Appeal Decision

Appeal Ref: APP/R5510/W/20/3261814

Land adjacent to 87 Mulberry Crescent, West Drayton UB7 9AQ

- The appeal is made under section 78 of the Town and Country Planning Act 1990 against a refusal to grant planning permission.
 - The appeal is made by Mr Ahsan Khan against the decision of London Borough of Hillingdon.
 - The application Ref 6476/APP/2020/1931, dated 25 June 2020, was refused by notice dated 26 August 2020.
 - The development proposed is demolition of existing single storey side extension & creation of new 1-bed dwelling house.
-

Stage: Planning	Job Title: New Dwelling	Job Number: 20190517A	Drawing Number: 03			
	Client: Ahsan Khan	Scale: 1:100 @ A3	Revision Suffix:			
Drawing Title: Proposed Elevations	Site Address: 87 Mulberry Crescent, West Drayton, UB7 9AQ	Date: 24/06/2020	A			
			Drawn By: AA	Checked By: -

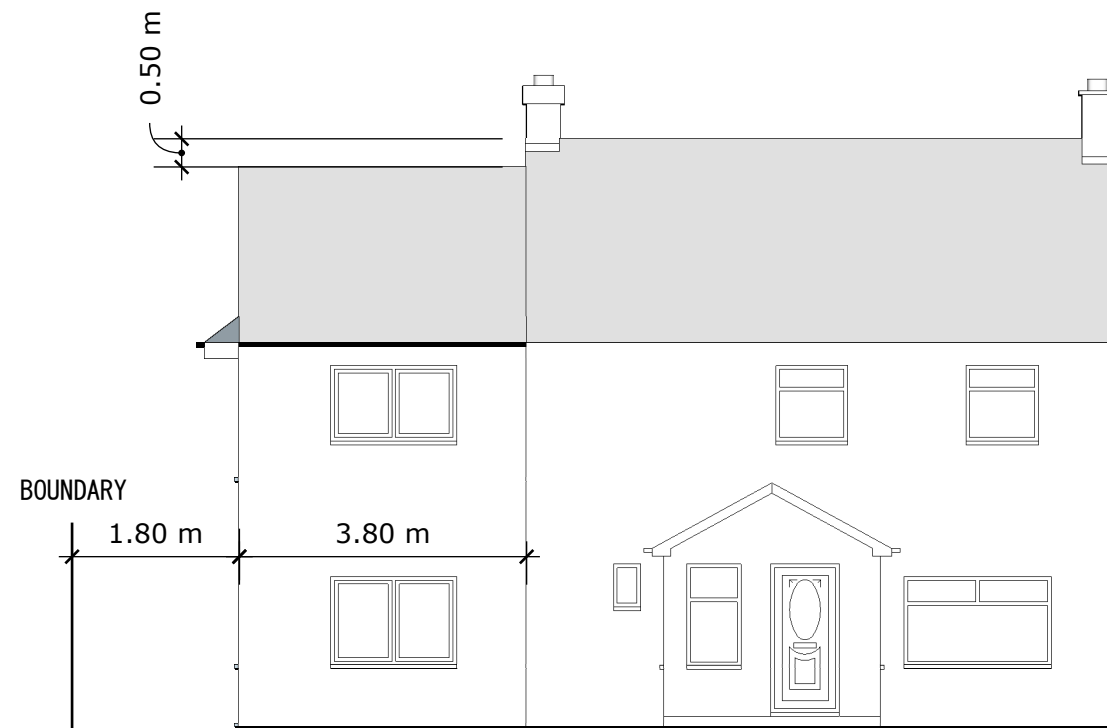
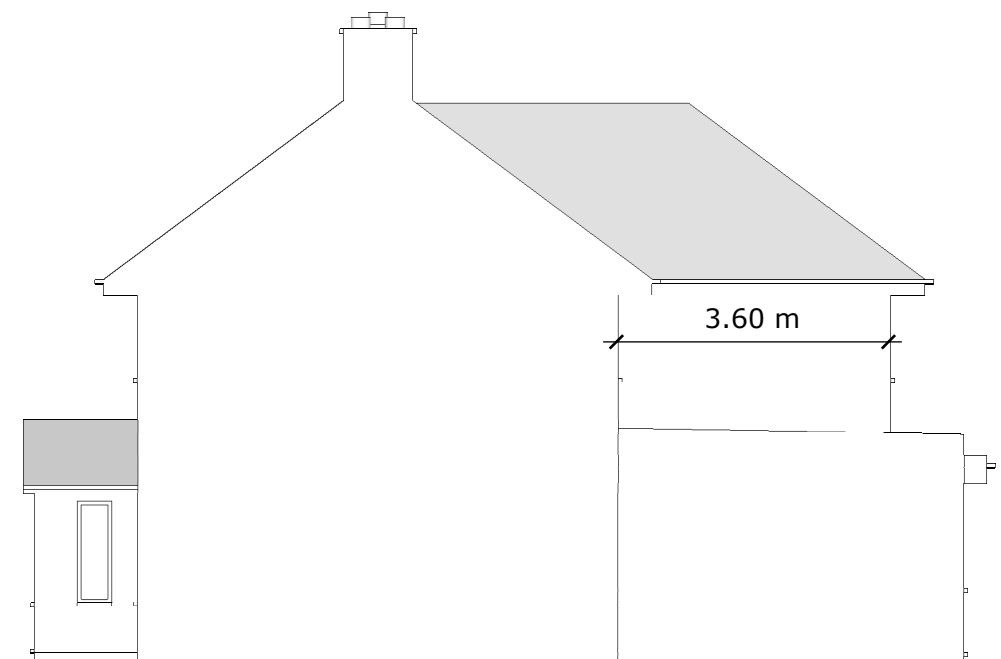
8. The proposal is to widen the single storey flat roofed extension, and also add a first floor wrap around extension to the side and the rear. Facing Mulberry Crescent the roof would be set down.

9. There would be a 1.8 m gap between the appeal property to the boundary with 2 and 4 East Wood Road. Even with the set down in the ridge line and the change in levels between properties this gap would also appear noticeably less than other gaps between buildings in the vicinity particularly at first floor level. This would mean that the proposal would appear cramped in the street scene and would be harmful to the character and appearance of the area and would harmfully reduce its spacious feel.

Stage: Planning	Job Title: New Dwelling	Job Number: 20190517A	Drawing Number: 04			
	Client: Ahsan Khan	Scale: 1:100 @ A3	Revision Suffix:			
Drawing Title: Proposed Floor Plans	Site Address: 87 Mulberry Crescent, West Drayton, UB7 9AQ	Date: 24/06/2020	A			
			Drawn By: AA	Checked By: -

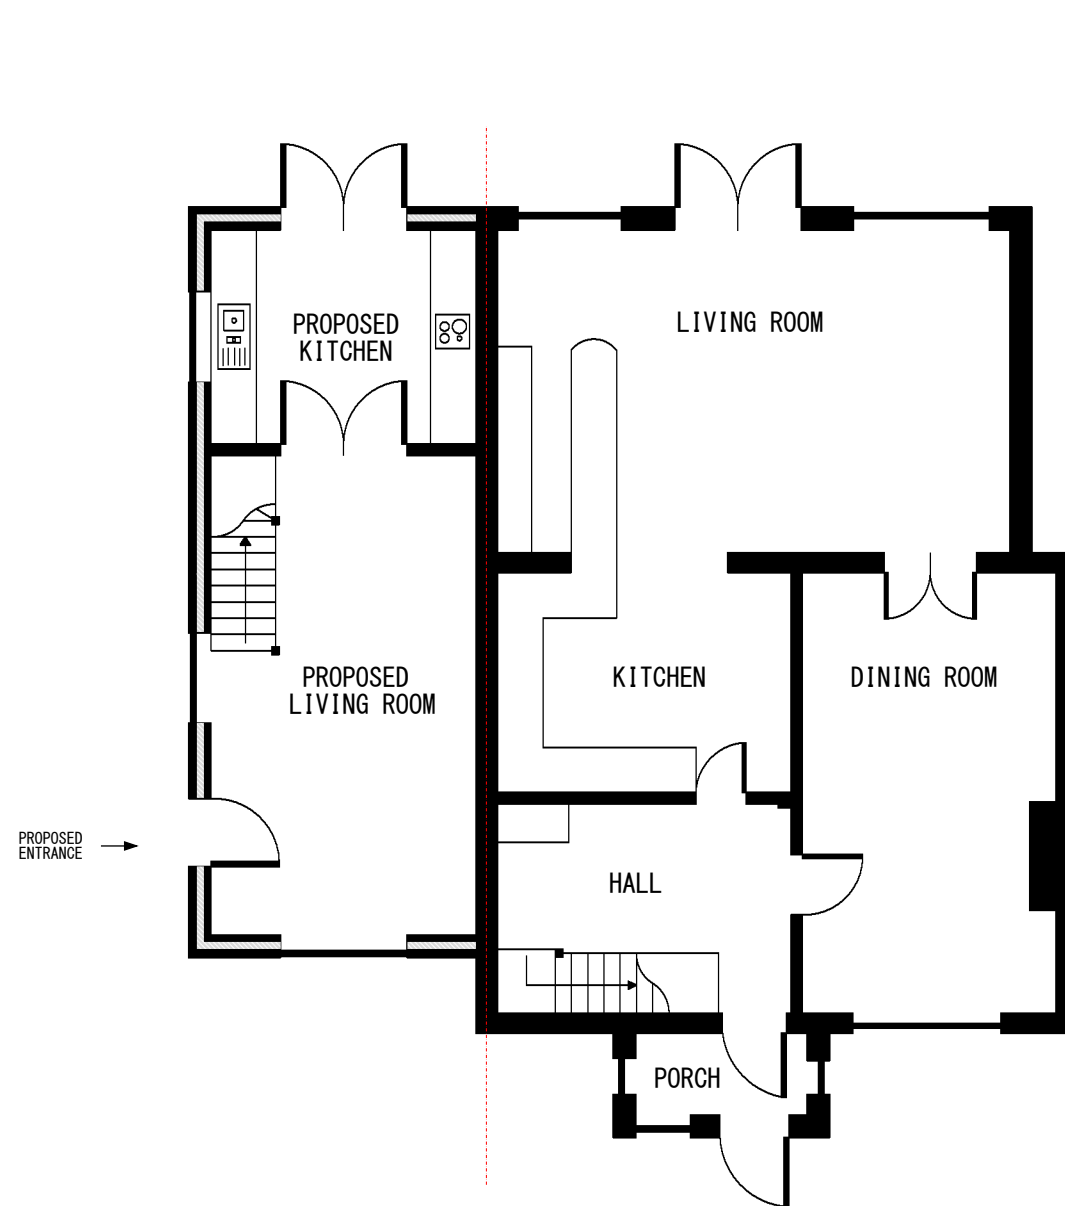
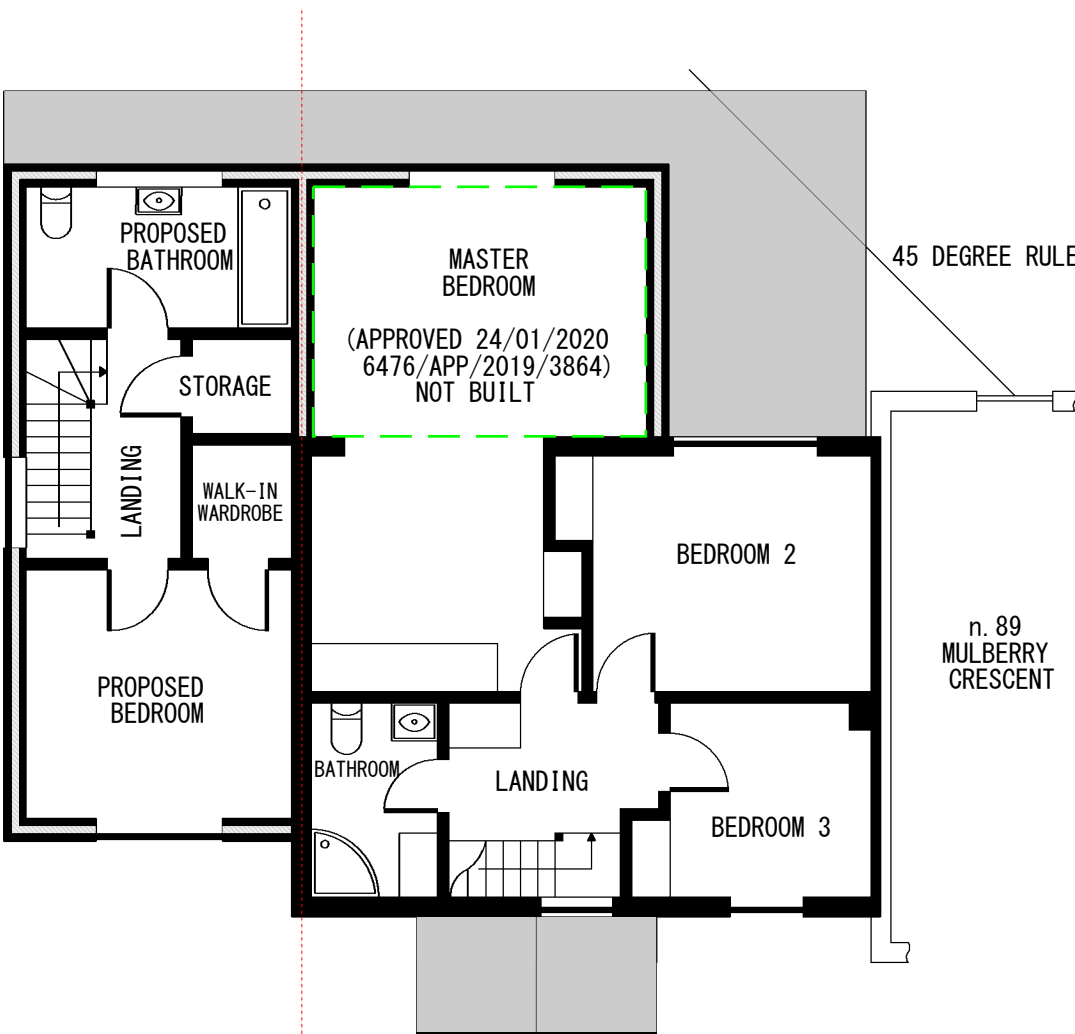
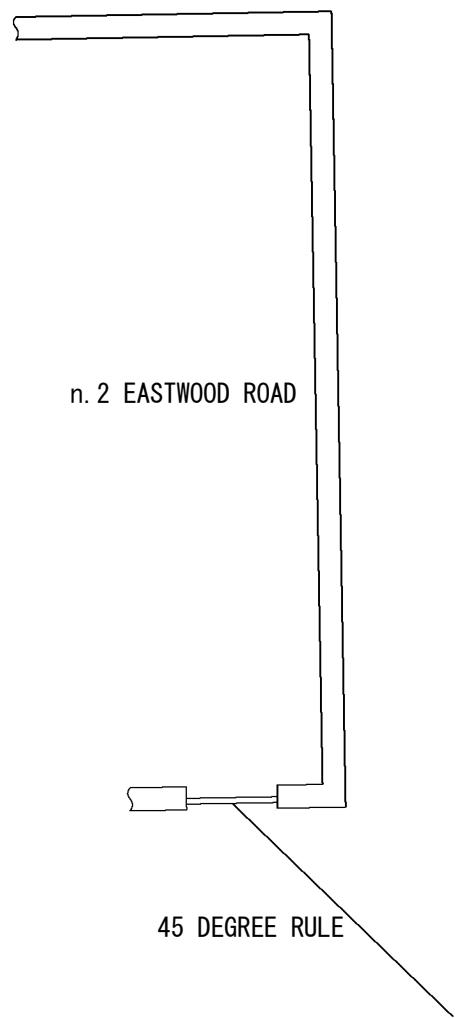
13. The proposed floor plan (Drawing 04 revision A) has two tables for the floor area of the dwelling. One, which has all the individual rooms, totals 56.87 m²,

but that for the GIA figure is 61.84 m². This difference would be explained by the internal walls which, as set out above, do not form part of the GIA figure. Therefore, the dwelling would meet the GIA figure required through Policy DMHB 16 of the LPP2 and Policy D6 of the London Plan 2021.

14. However, a planning permission grants permission for both the external and internal layout, and the layout does not show how step free access could be delivered or include provision for a WC on the ground floor.

15. I have considered whether this could be secured by condition, as Policy D7 of the London Plan 2021 does indicate that the relevant requirement can be secured in this way. In considering this there does have to be a reasonable prospect that the condition could be complied with. Given the location of the existing entrance and the levels of the area I am satisfied that an accessible access could be provided. However, given the layout of the ground floor of the dwelling and the location of the various windows, I am not satisfied that a WC could be achieved at entrance level, as either circulation within the dwelling or light to rooms would be compromised.

16. That being the case, while the property would be of suitable size, and could have an accessible entrance it would not provide for a WC at entrance level. Consequently, while the proposal would comply with Policy DMHB 16 of the LPP2 as set out above, it would be contrary to Policy D7 of the London Plan. It would also be contrary to paragraph 127 and footnote 46 of the Framework which indicates planning policies for housing should make use of the Government's optional technical standards for accessible and adaptable housing.

Stage: Planning	Job Title: New Dwelling	Job Number: 20190517A	Drawing Number: 05			
	Client: Ahsan Khan	Scale: 1:150 @ A3	Revision Suffix:			
Drawing Title: Proposed Block Plan	Site Address: 87 Mulberry Crescent, West Drayton, UB7 9AQ	Date: 24/06/2020	A			
			Drawn By: AA		Checked By: -

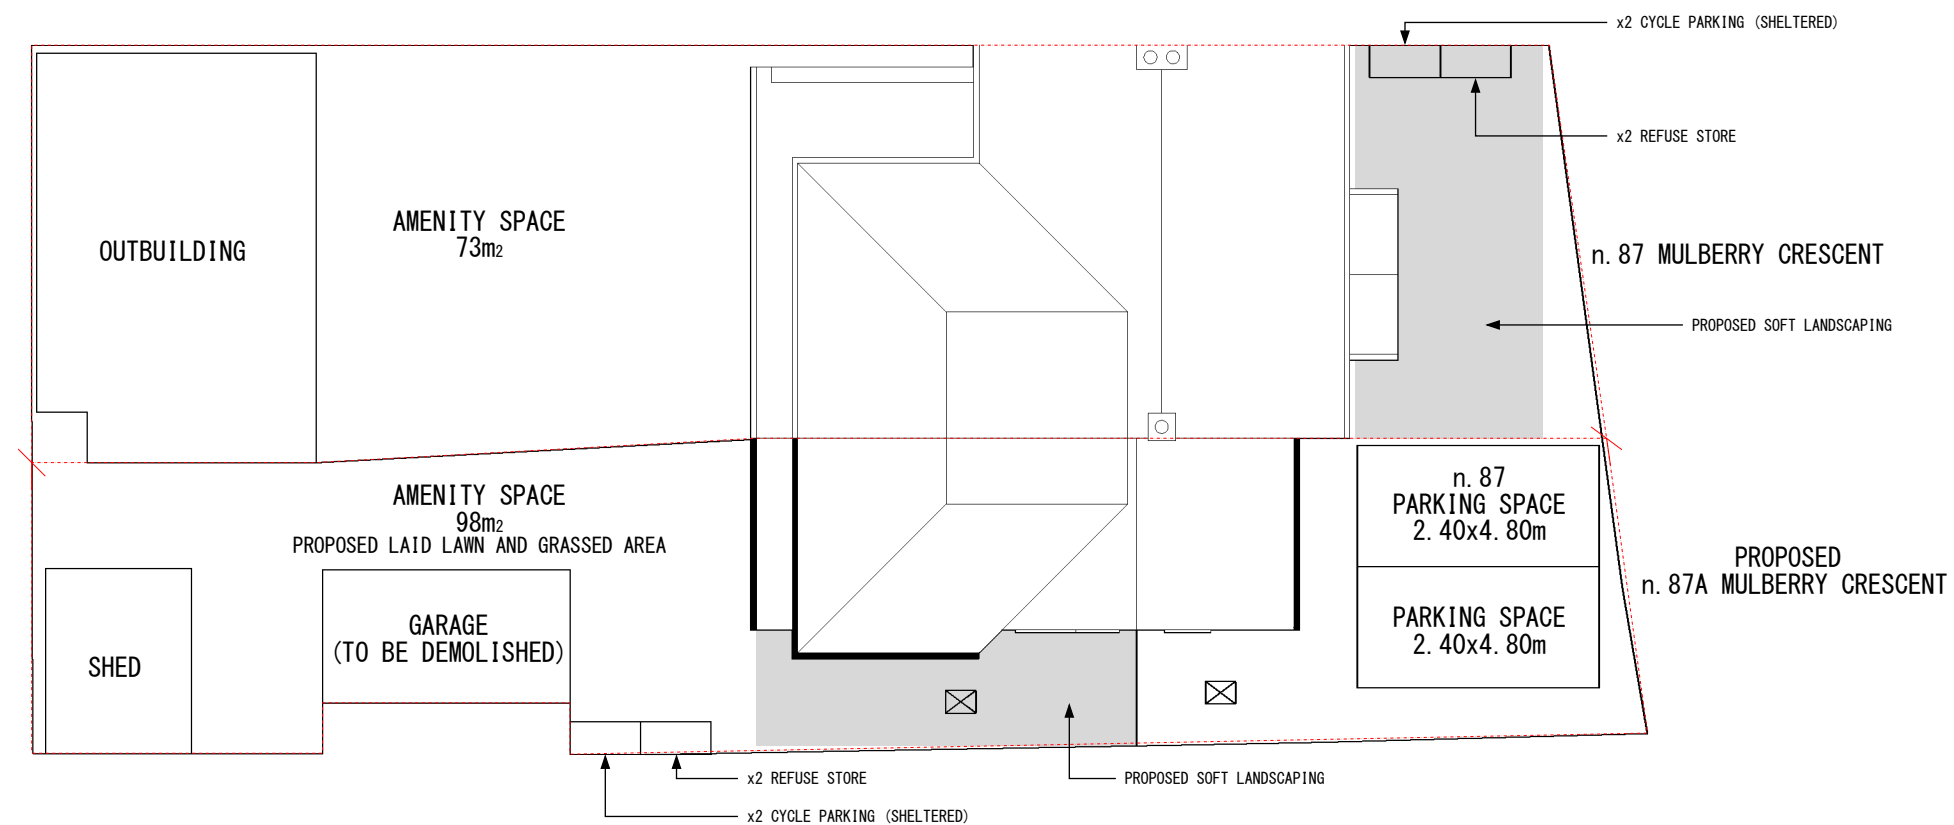
17. Currently there is room for two vehicles to be parked on the site in front of the dwelling. Policies DMT 2 and DMT 6 of the LPP2 require safe and efficient vehicular access and for development to provide appropriate parking in line with relevant standards. Policy DMT 6 indicates these standards can be varied where there would not be a deleterious impact on street parking provision, congestion or local amenity. The standards require two spaces on-site for three-bedroom dwellings and one space for one-bedroom dwellings. Therefore, for the purposes of this appeal, as there would be two dwellings as a result of the proposal, three on-site spaces should be secured and only two are shown.
